PLAN REVIEW SHEET

Date: March 25, 2021

Petition #: RZP 2021-033

Address: 1335 South Clarkson Street, Charlotte Pipe and Foundry

RZ-1.0

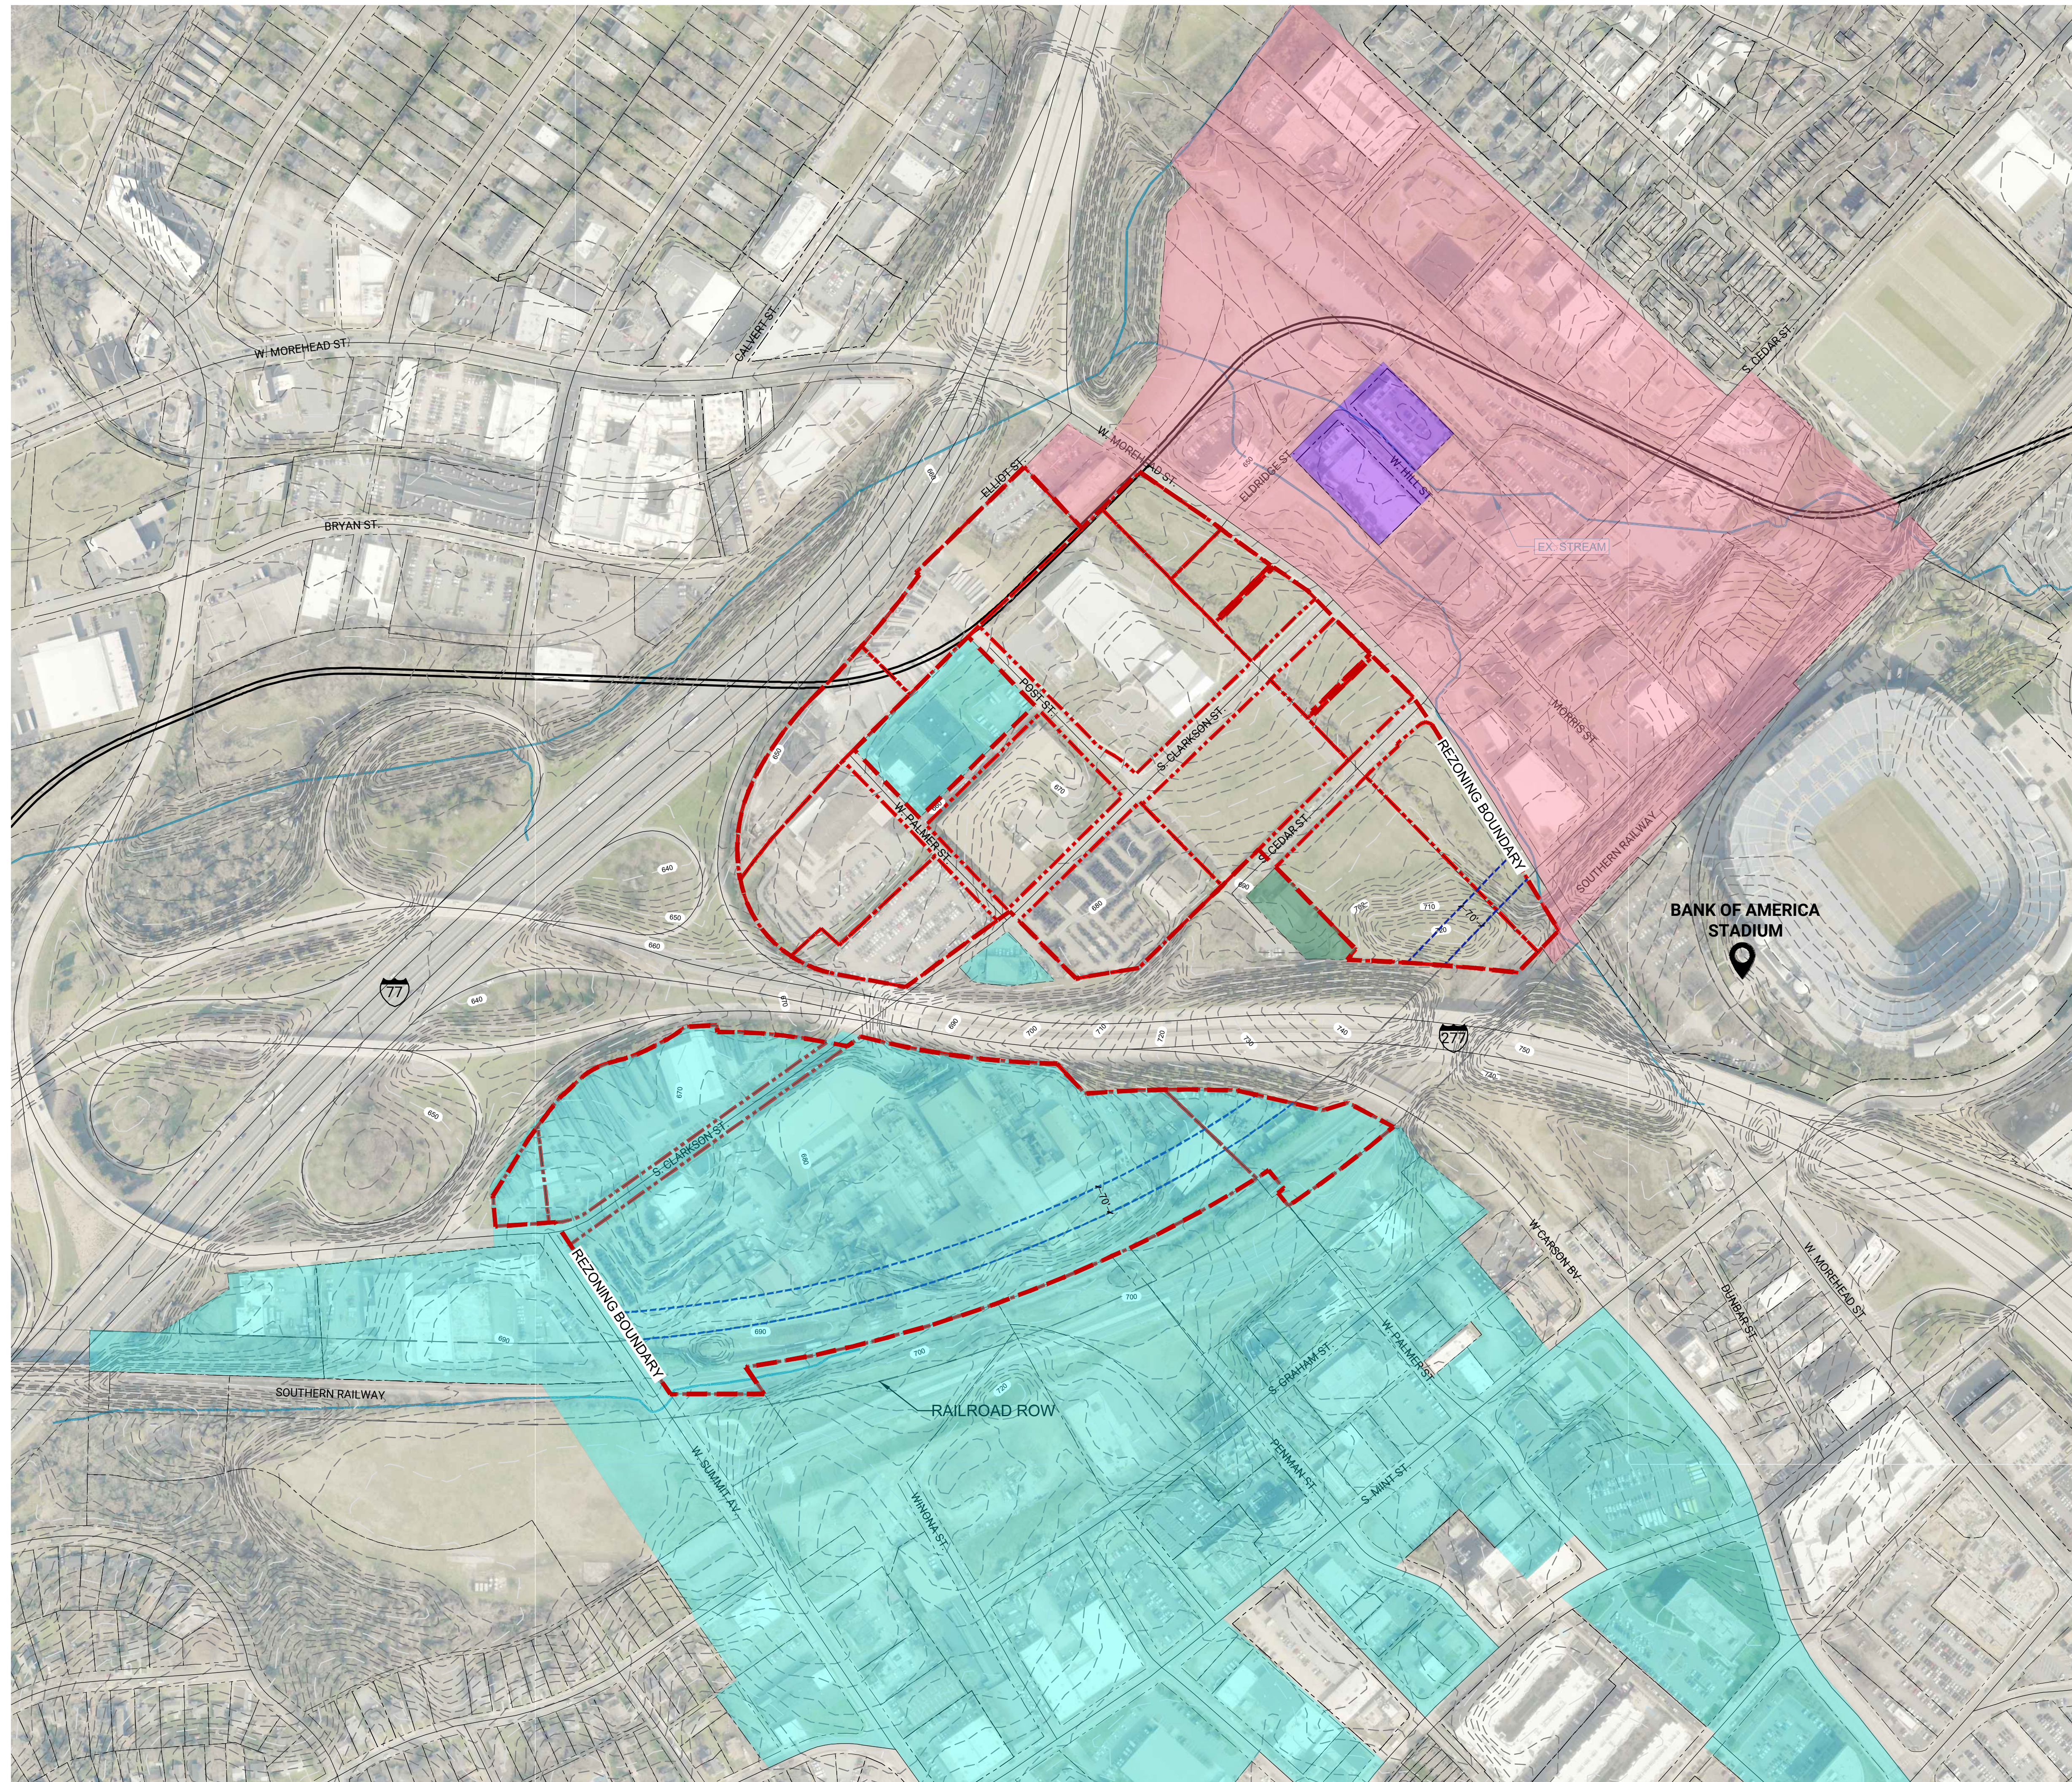
The site associated with Petition #2021-033 is adjacent to the revised LYNX Silver Line light rail transit corridor, and along the Norfolk Southern rail corridor. The required right of way for the light rail corridor is a minimum 70 feet (35 feet measured from the centerline of the tracks). CATS is requesting a conditional rezoning petition to include the reservation of the light rail corridor.
